Re: Taco Bell Site Plan Amendment

At Dev Rev today the others recommended that they relocate the dumpster to the right and angle it (so would take another parking space), and then put planting between it and the new drive and add another sign at the corner of the new drive identifying it.

CONCEPT PLAN

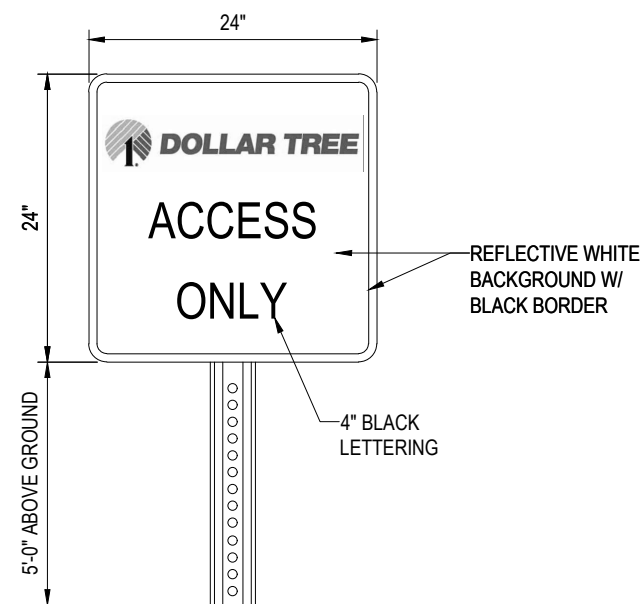
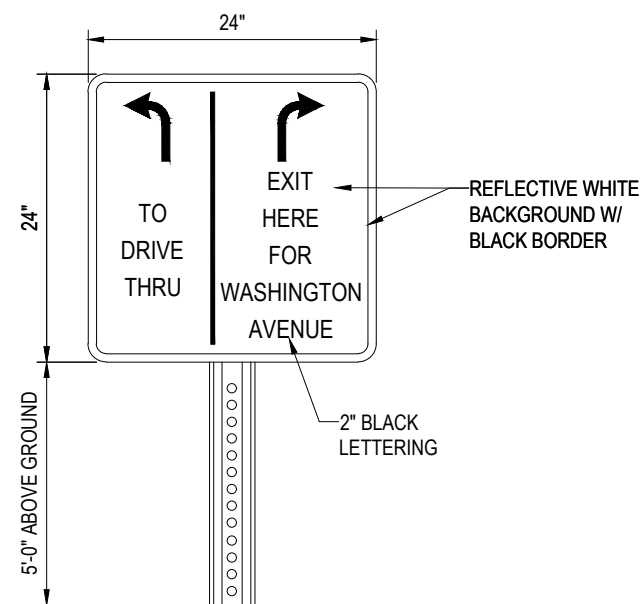
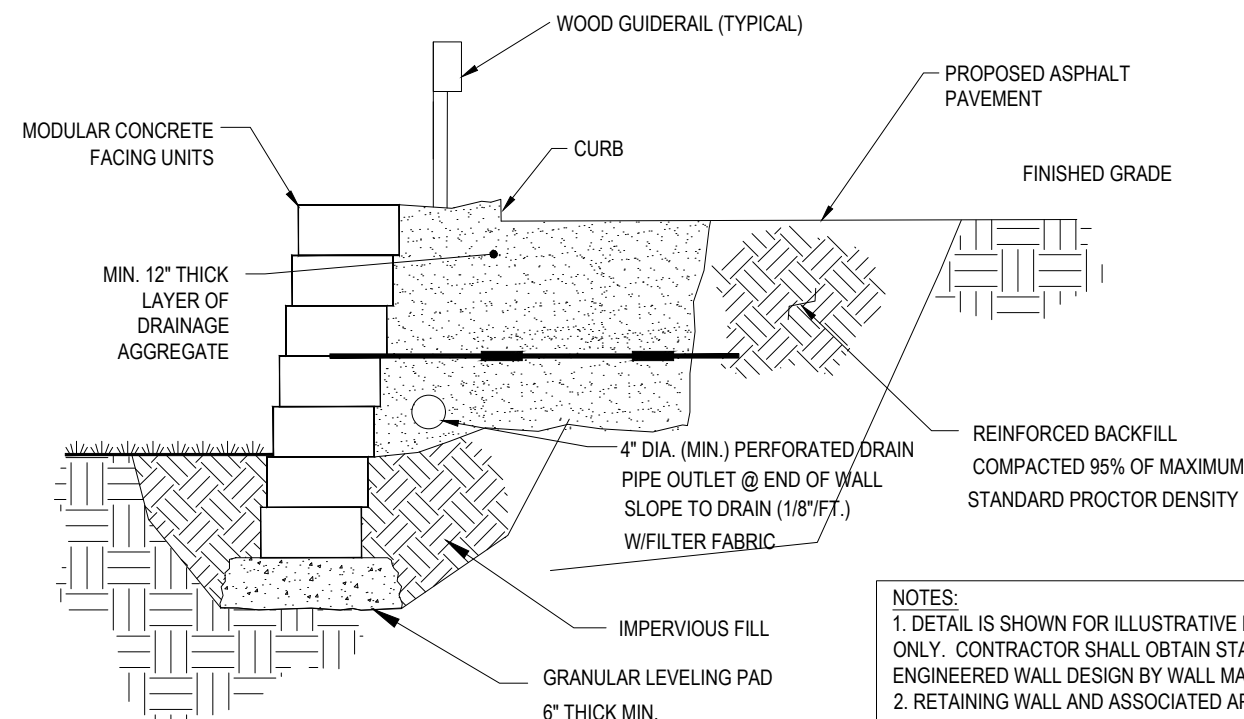
This brings the parking from 14 (as approved) to 12 - which I think is OK from a zoning viewpoint (I would need them to send a floorplan to document that).

I'm fine with that change
